**Our ref:** NO/2017/109982/01-L01  
**Your ref:** 3/2017/0433  
**Date:** 05 July 2017

**APPLICATION FOR OUTLINE PLANNING PERMISSION FOR UP TO 25 NEW DWELLINGS AND ASSOCIATED INFRASTRUCTURE ON LAND BEHIND 115 KEMPLE VIEW, CLITHEROE INCLUDING ACCESS VIA HENTHORN ROAD LAND OFF HENTHORN ROAD CLITHEROE BB7 2QF**

Indicative Evolving Scheme plan

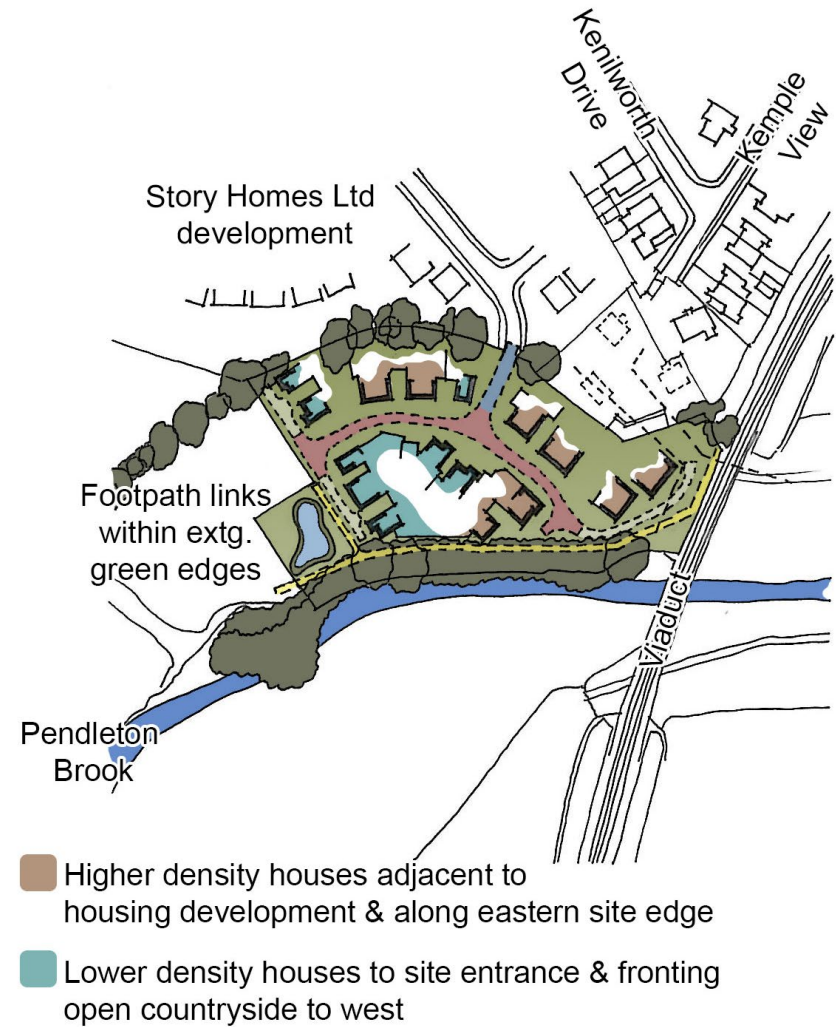
The development of permanent structures, private gardens and garden fencing within our 8 metre easement will not be permitted. The illustrative scheme (drawing number 17/018/P01 'Indicative proposed site plan' dated 22/03/17) would not be acceptable and our consent would not be forthcoming for this layout.

The FRA should also consider how access to Pendleton Brook will be retained for future flood risk maintenance and / or improvement works. The extent of the Environment Agency easement through the site in relation to the top of the bank of Pendleton Brook should be defined.
